# **PLANNING STATEMENT**

38-40 LANCASTER ROAD, UXBRIDGE, UB8 1AR

OCTOBER 2023

This Statement has been made in response to the London Borough of Hillingdon council enforcement investigation at 38-40 Lancaster Road Uxbridge UB8 1AR. This brief statement has been produced in support of the retrospective application to vary conditions Two (2) and Five (5) of planning permission reference 19030/APP/2021/3857 of planning granted for '*Demolition of the existing sheds and erection of two semi-detached 3-bedroom houses with private gardens and car parking area*'. In this proposal, both applications referenced 19030/APP/2021/3857 &19030/APP/2022/2194 should be carefully considered.

PROPOSED REAR ELEVATION - 'AS BUILT'
(SCALE 1:100)

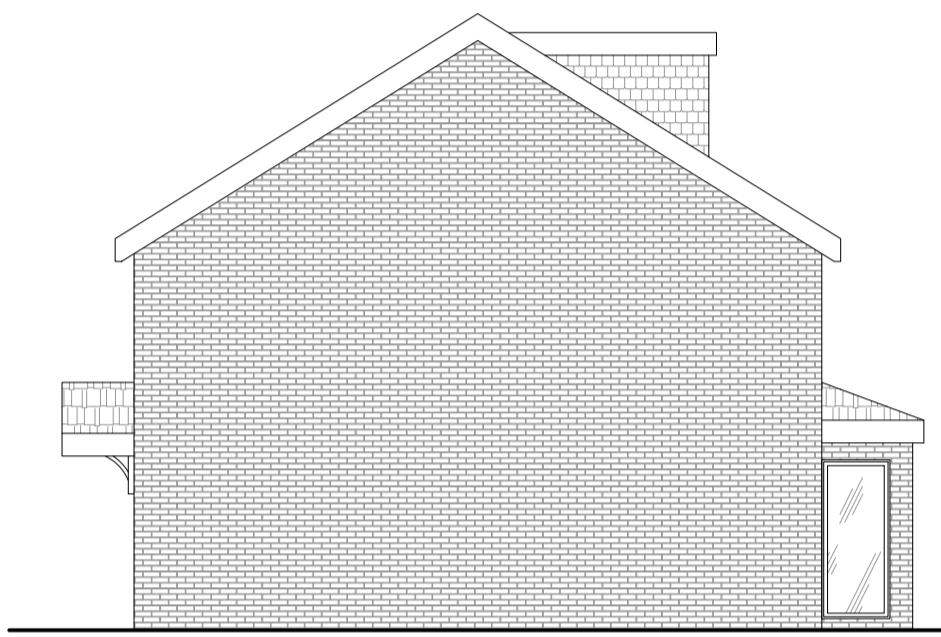
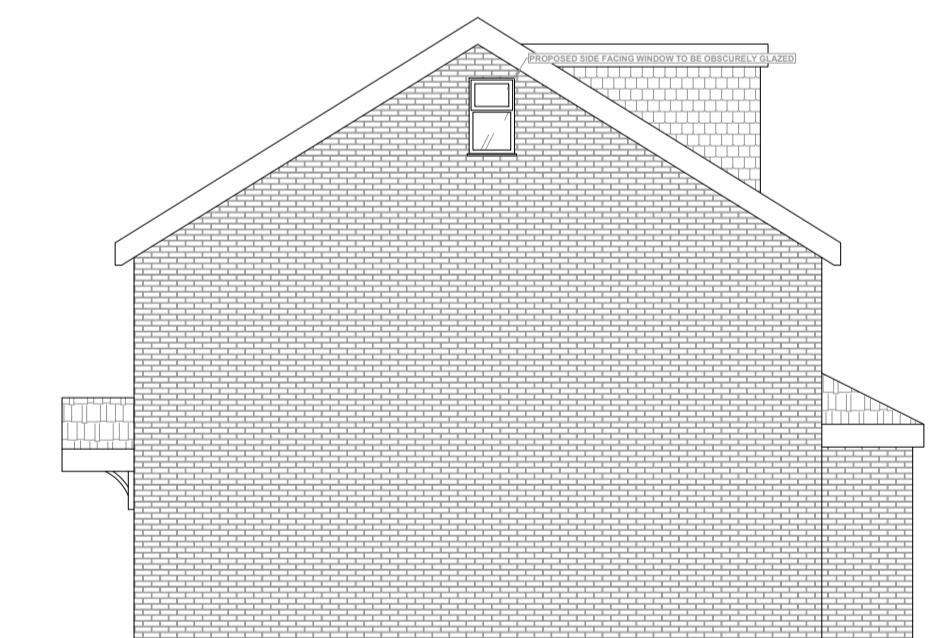
The have been some visible changes to fenestration. However, none of these alterations have an overbearing or significant impact on neighbouring properties. The major changes to fenestration are to the GF rear elevation of the property. The additional small bathroom window at loft floor level is obscurely glazed, this should not result in any issues in terms of privacy, this window is also non openable below 1.7m above FFL. All changes can be clearly seen when compared on drawings KKC/LR/2023/Z1& KKC/LR/2023/Z2.

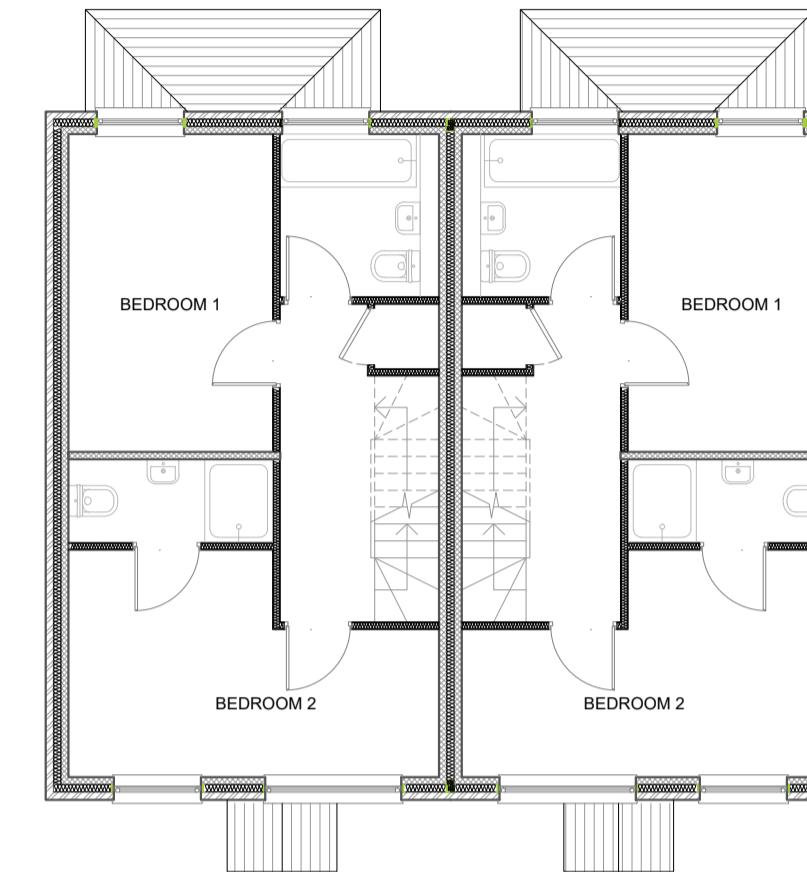
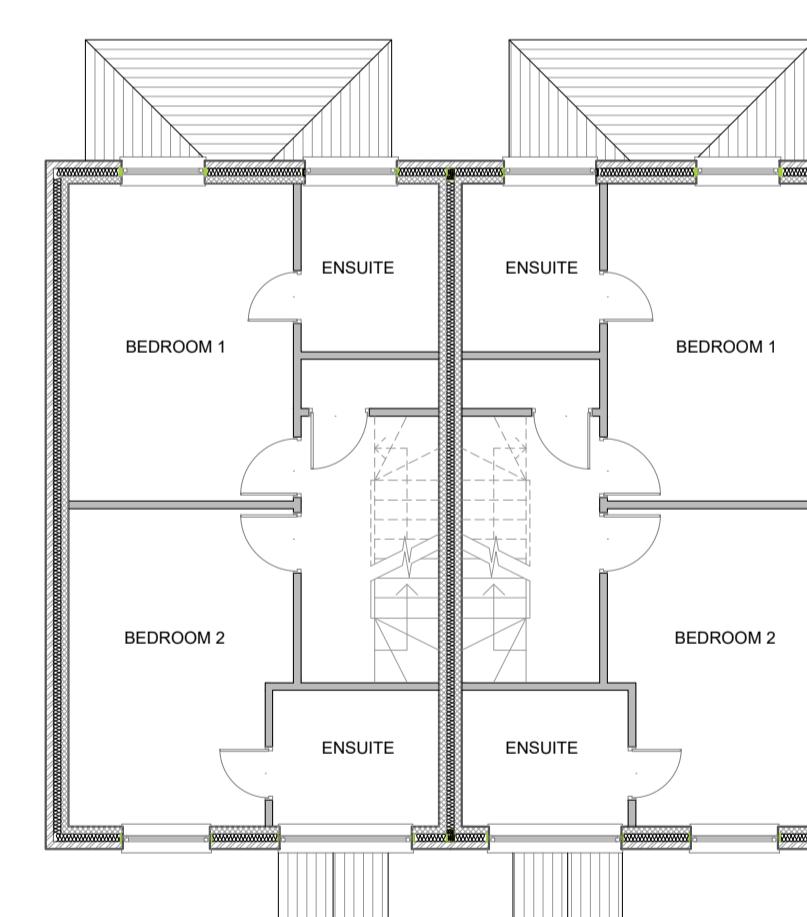
The footprint area and scale of both examples is identical and as per approved plans. However, there have been some minor alterations on site. Finally, the internal alterations have still provided a 3-bedroom property with adequate amenity space, it is not in exact compliance with previous approvals, but no additional bedrooms/amenity space has been provided. The most significant alteration is that the kitchen and living space have been re-allocated.
